1
SK3 EXISTING WEST ELEVATION
Scale: 1/4"=1'-0"

EXISTING ELEVATIONS & ELEVATION SHOWING PROPOSED AWNING

1 EXISTING WEST ELEVATION
 A2.1 Scale: 1/4"=1'-0"

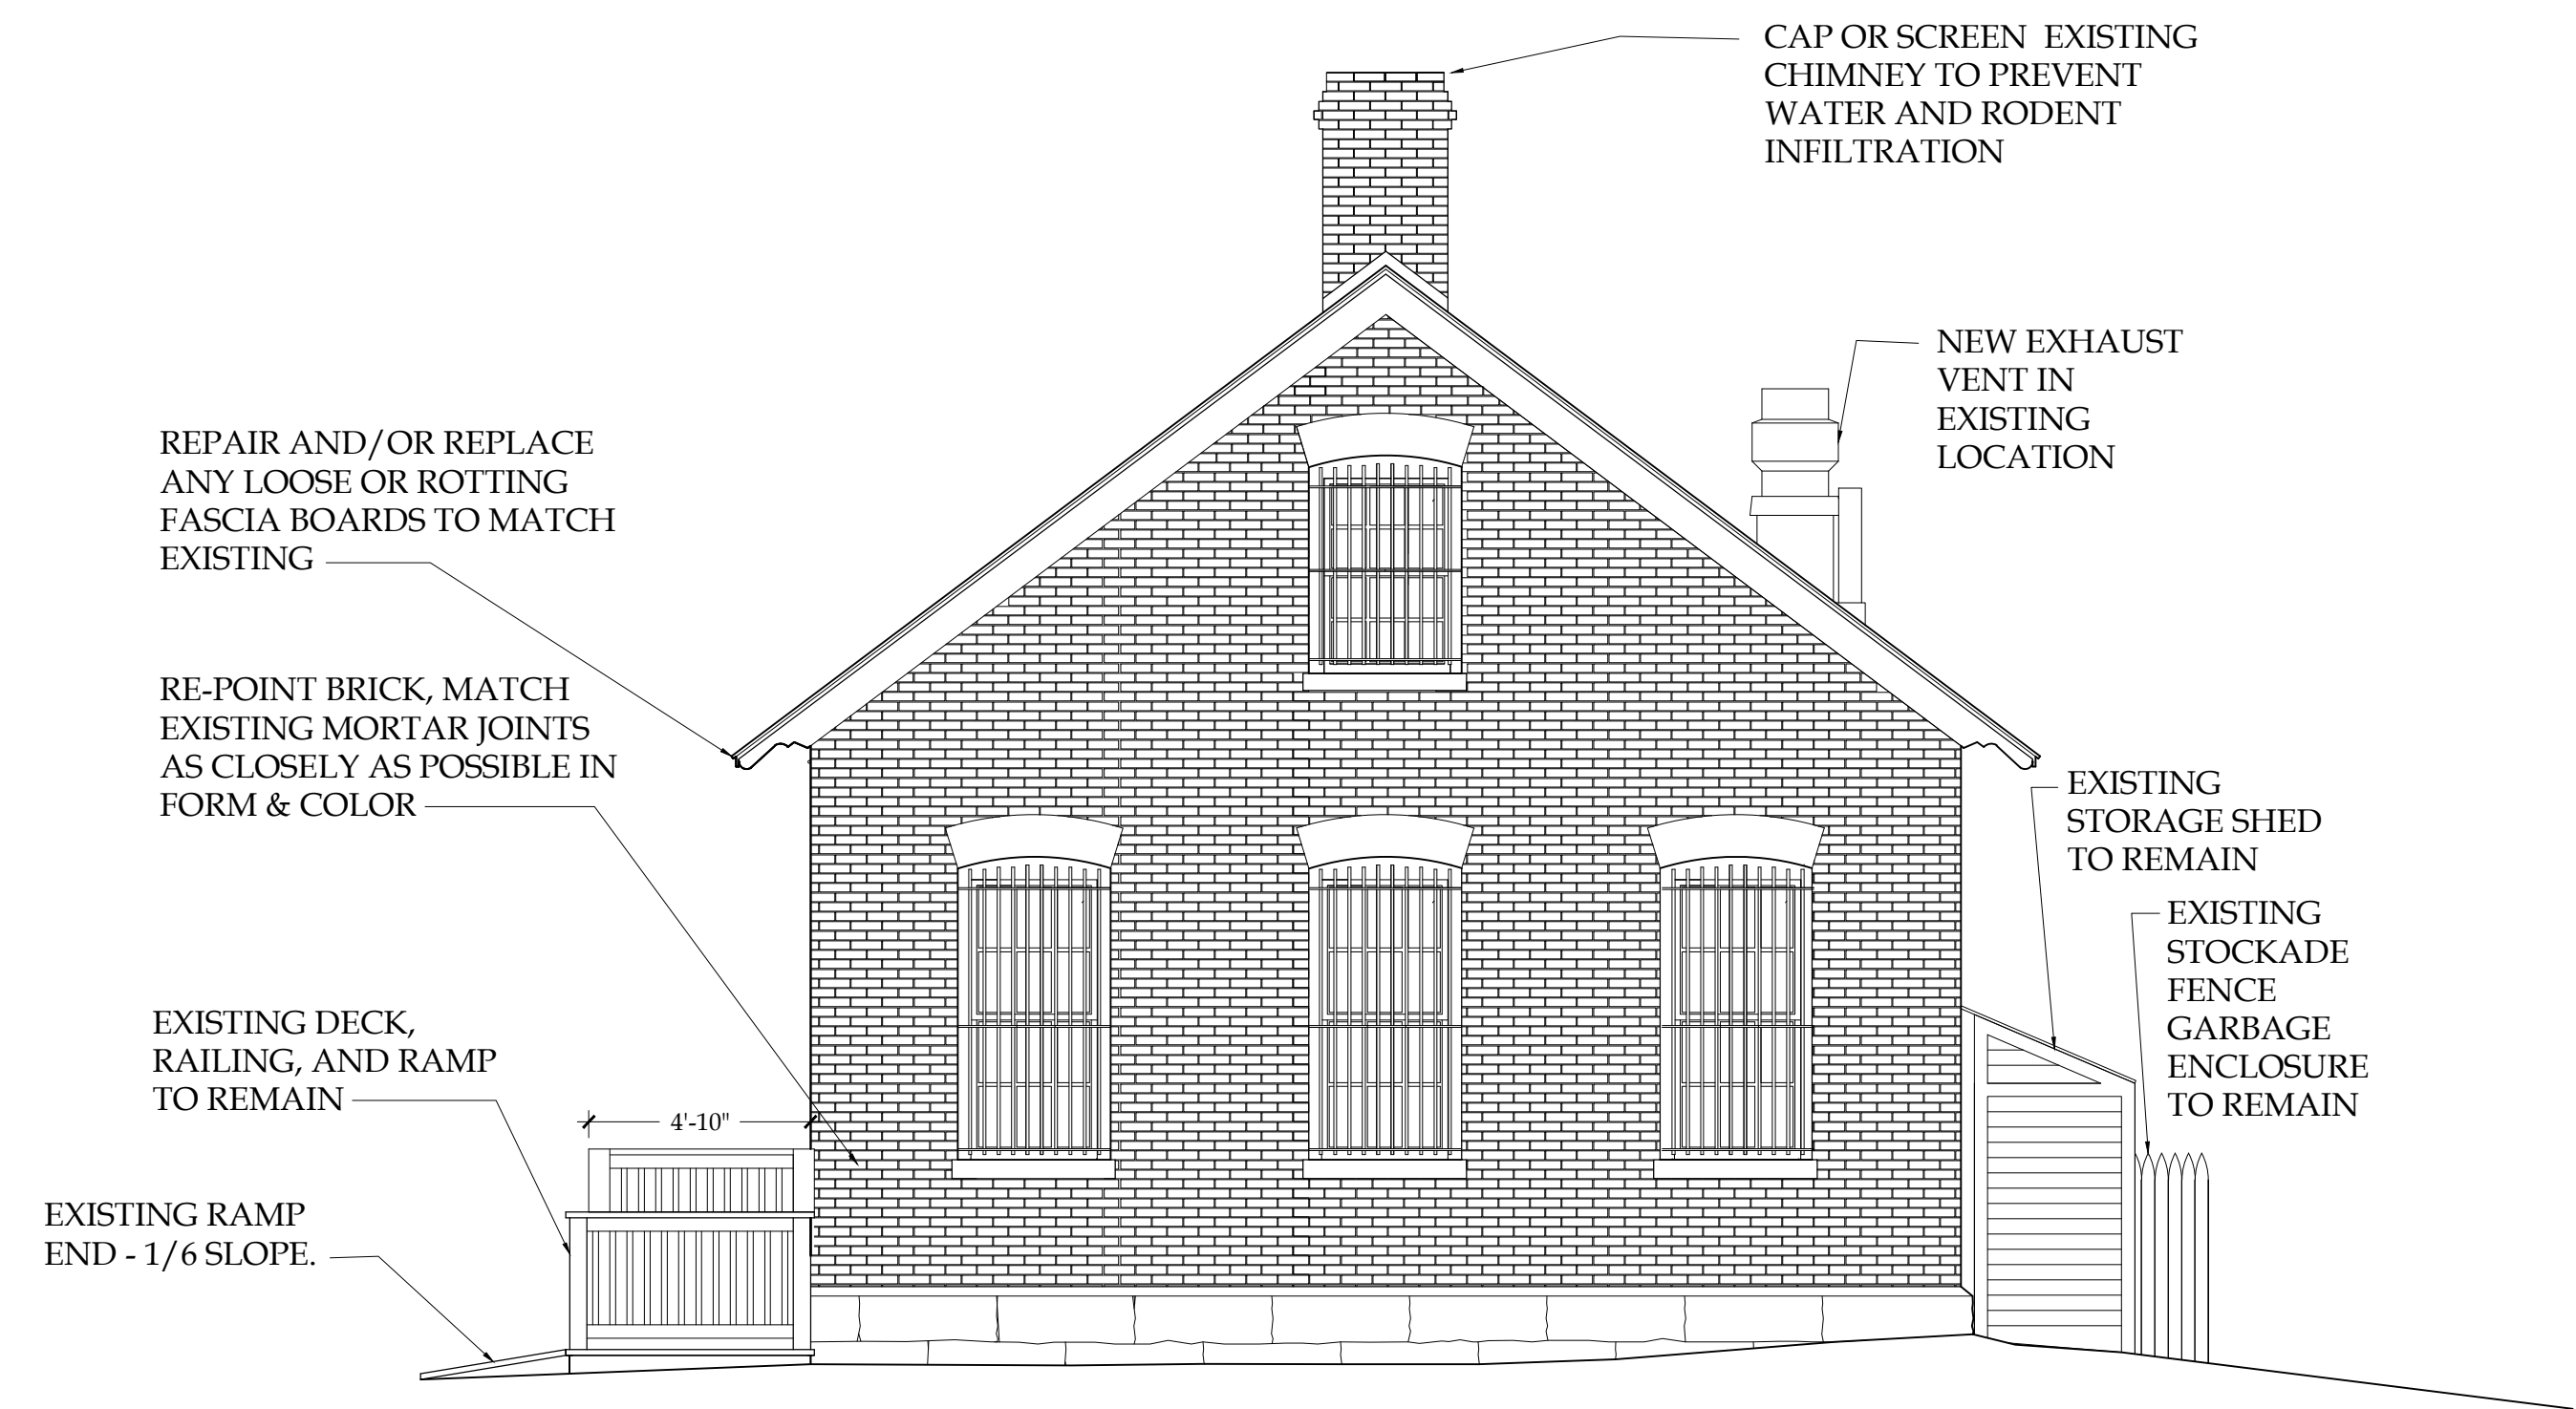
Show stairways as per IBC Section 1009 (show riser height, tread depth, handrail locations and returns, guard height and stair profile).

Show rise of ramp maximum 30" as per ADA Standards Section 405.6

Show slope of ramp maximum 1:12 as per ADA Standards Section 405.2

Show required handrails as per IBC Section 1012 (show locations, heights and returns).

Show required guards as per IBC Section 1013 (show height, opening size and construction).

Show required edge protection as per ADA Standards Section 405.9
